**CITY OF ALBUQUERQUE
PLANNING DEPARTMENT
April 25, 2007
DRB Comments**

PROJECT # 1005519

**RE: Tracts 309A & 309B, MRGCD Map #35 tbk Lands of Ventura
M. Ramirez/sketch**

DEVELOPMENT REVIEW BOARD – SPEED MEMO

SKETCH PLAT OF
 LOTS 1, 2 & 3
 LANDS OF VENTURA M. RAMIREZ
 SECTION 12, T. 10 N., R. 2 E., N.M.P.M.
 CITY OF ALBUQUERQUE
 BERNALILLO COUNTY, NEW MEXICO
 APRIL 2007
 SHEET 2 OF 2

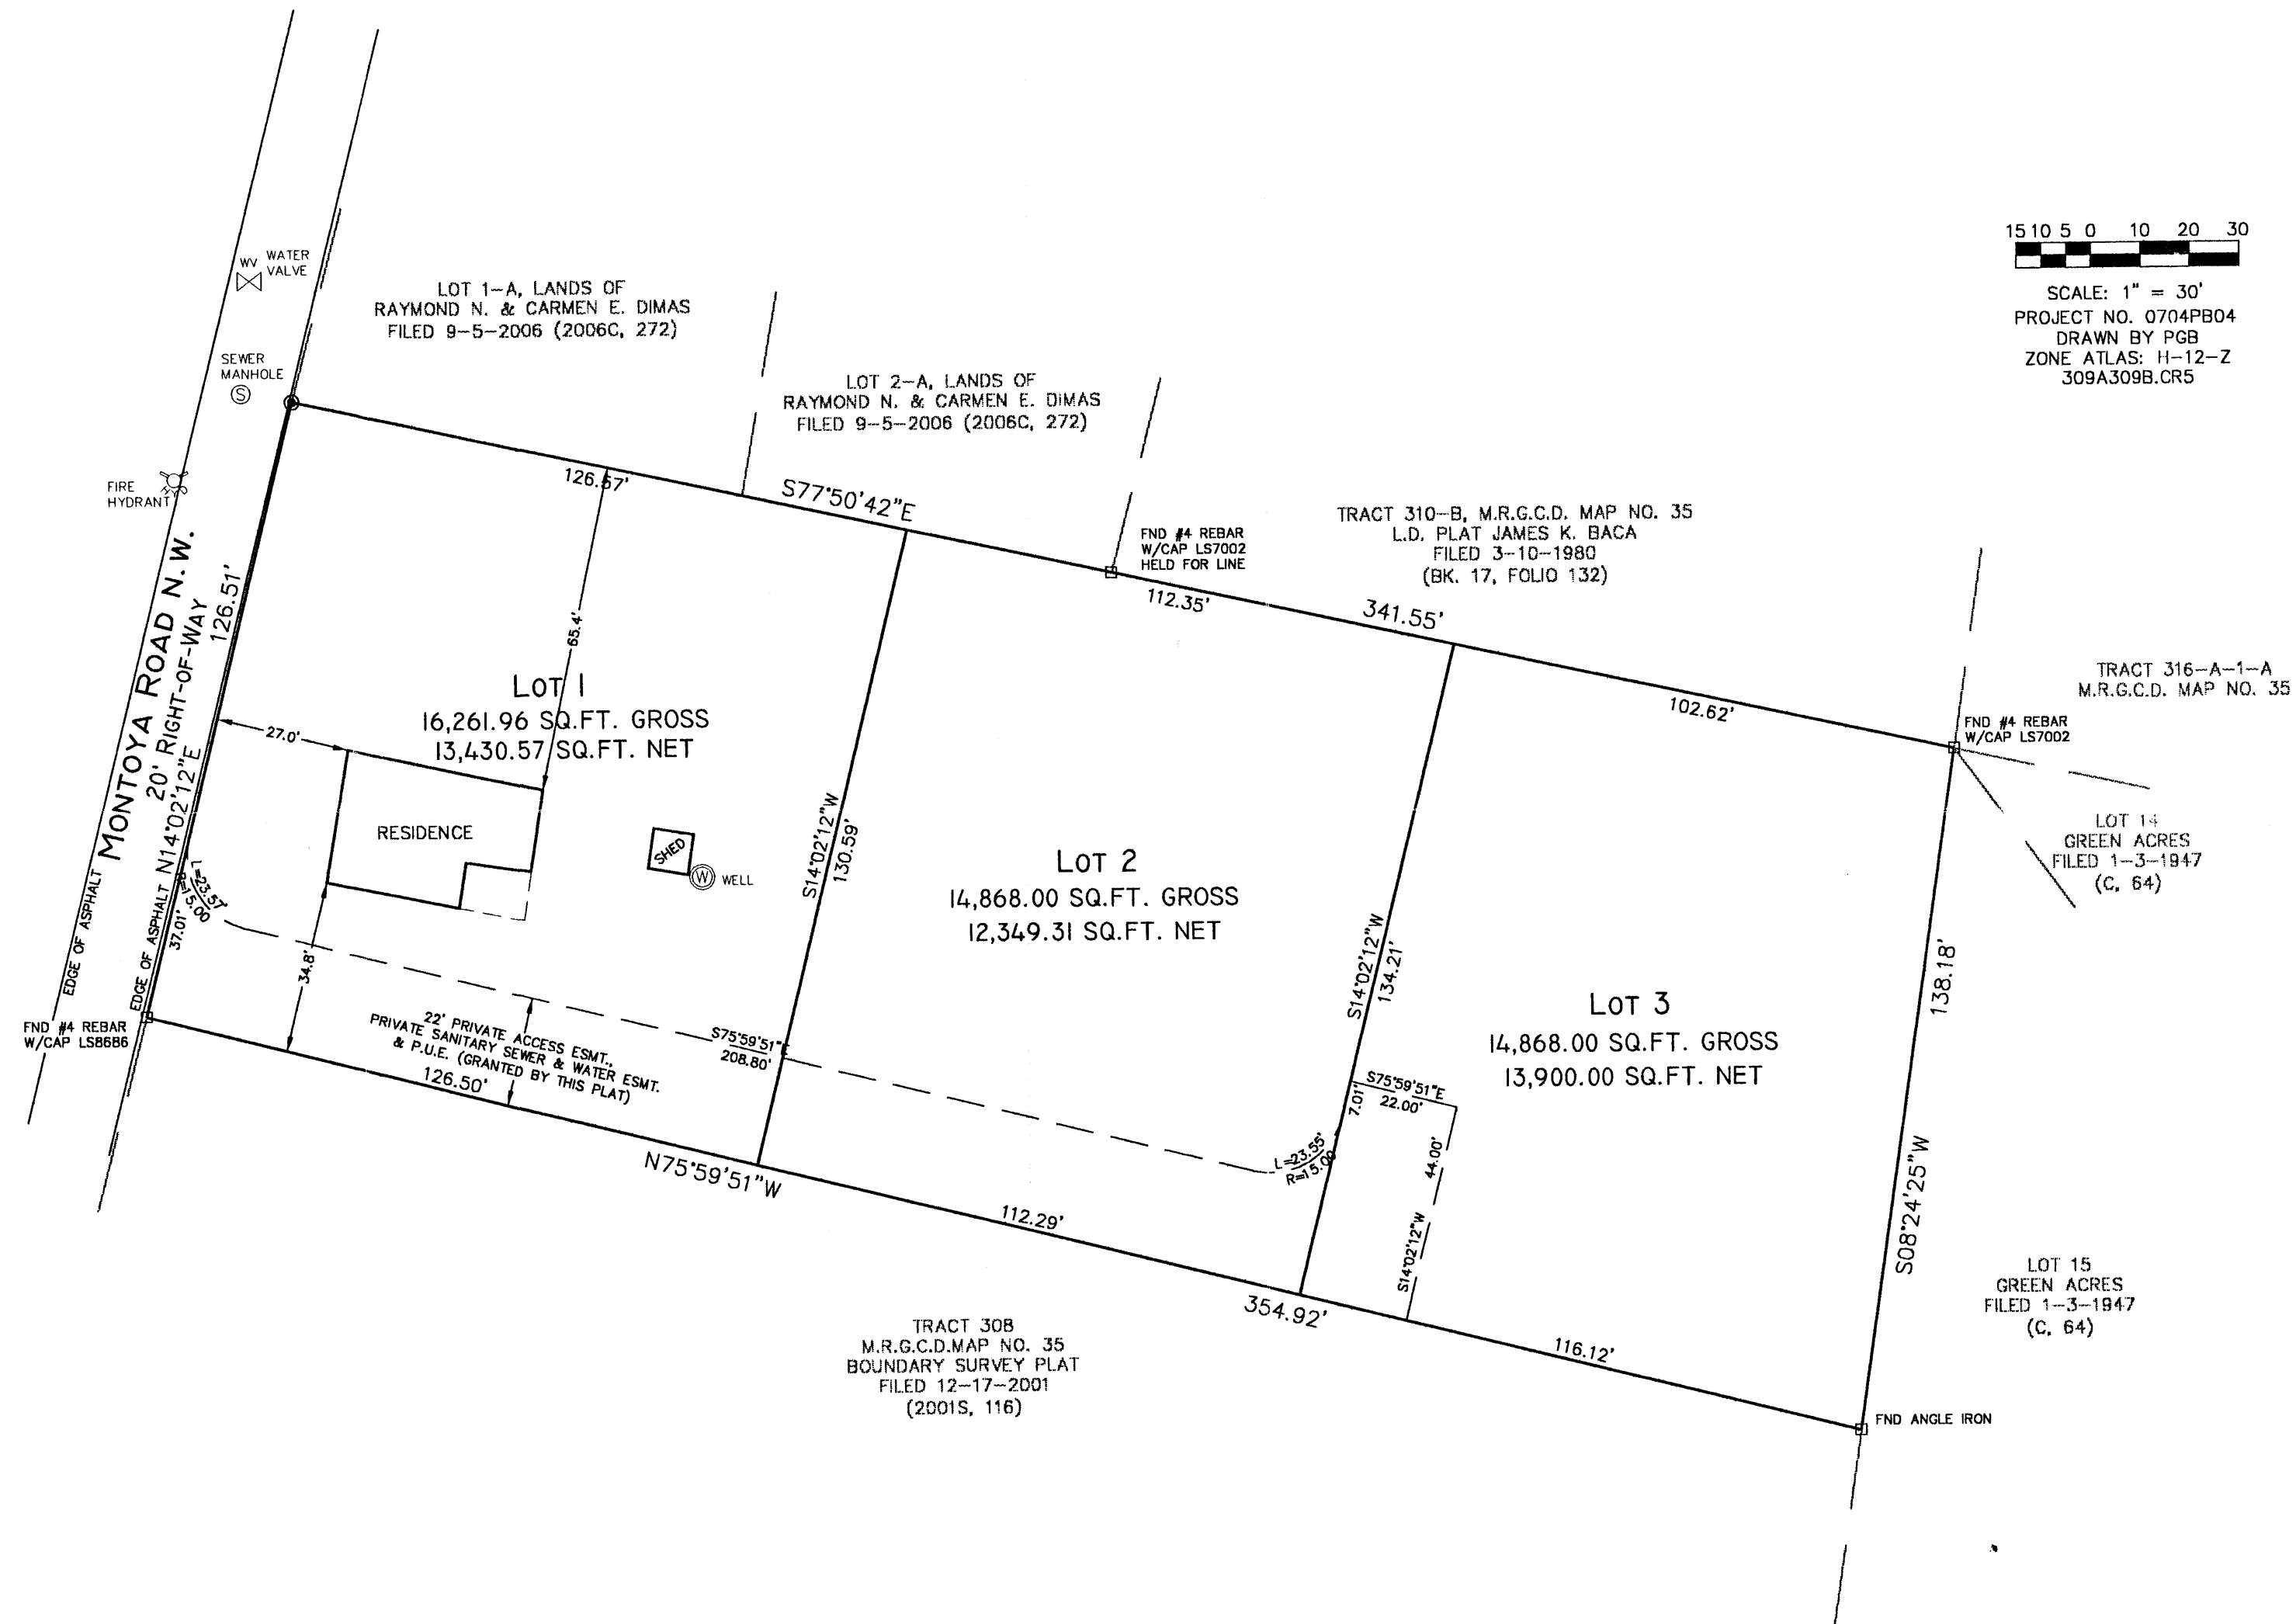
A cross lot drainage easement will be required.

1. There is an existing 8" sewer line along the north edge of property. This line must be located to see if additional easement is required.
2. Show existing sewer and access easements along north edge of property.
3. Access road should be placed on north side of lots, not the south side because of the existing sewer line.
4. By Ordinance, must construct public water line along north side of property from Montoya Road to east boundary.
5. Should request a Water/Sewer Availability Statement.
